Our Ref: BR/304/19/PL

**Town & Country Planning Act 1990 (as amended)
Town and Country Planning (Development Management Procedure) (England) Order 2015
Application for Planning Permission**

Development	Installation of new entrance doors to shopfront, installation of air conditioning & re-colouring of existing shopfront
Location	9-11 Water Tower Buildings London Road Bognor Regis

BLOCK PLAN
SCALE 1:500

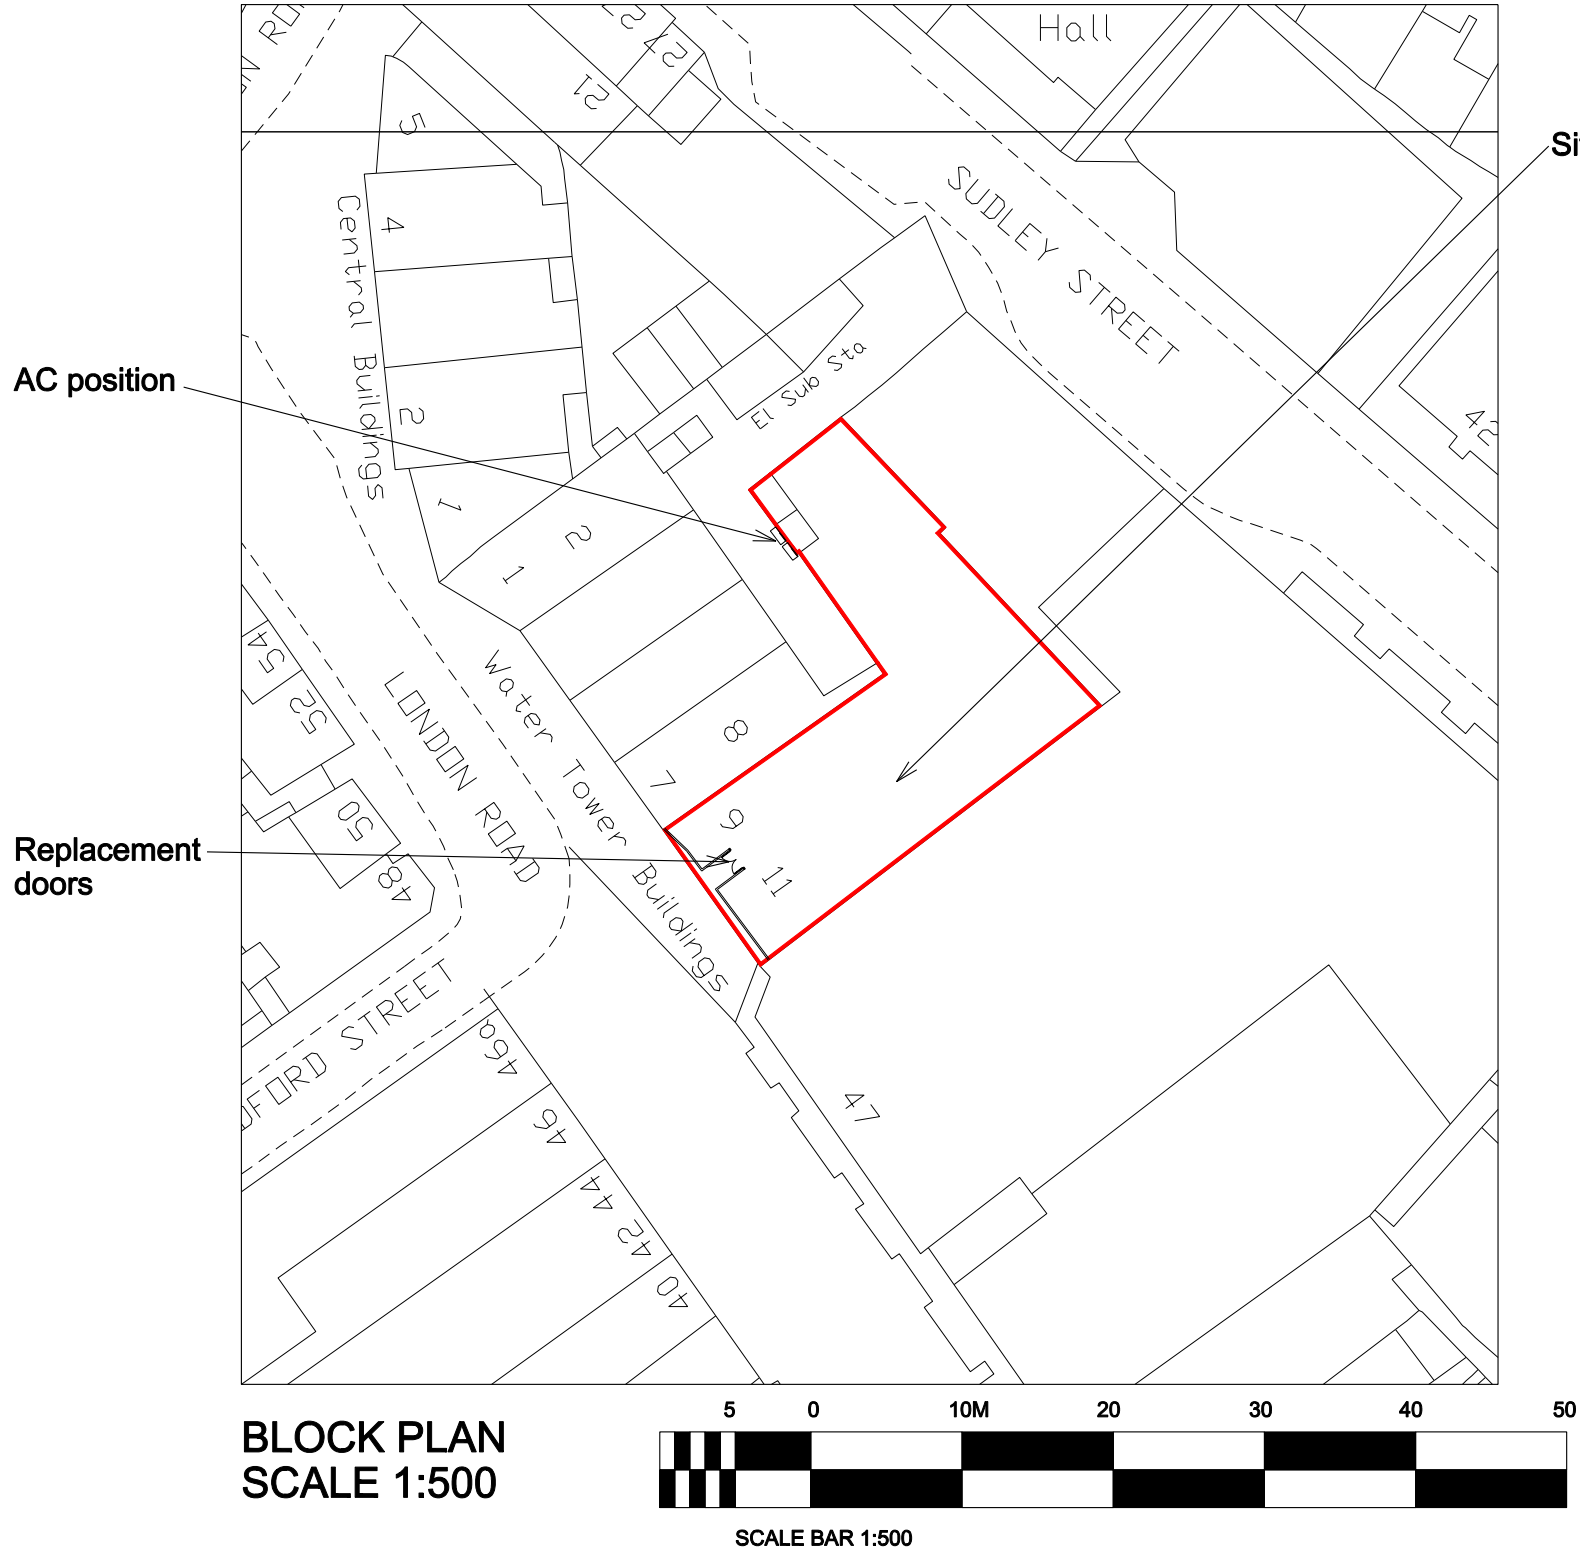
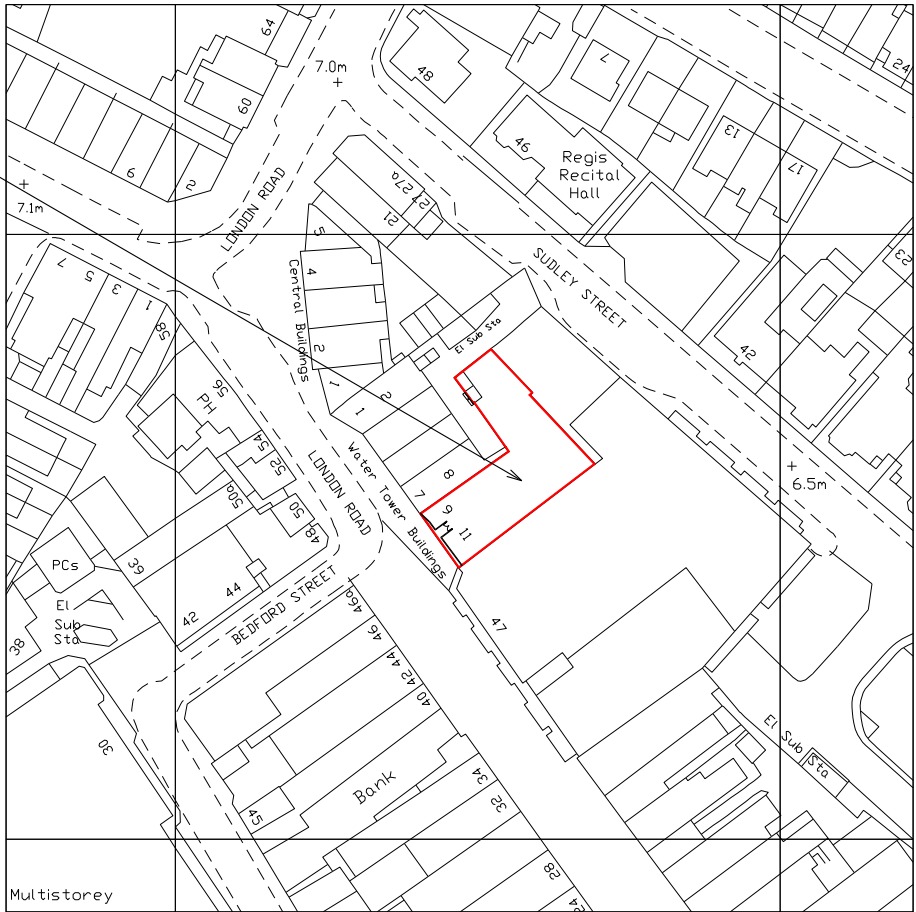
Block Plan

Please submit 1 electronic or 3 paper copies of an amended block/site plan at a scale of 1:500 or 1:200 clearly showing the position of the proposed works ie entrance doors/air con units
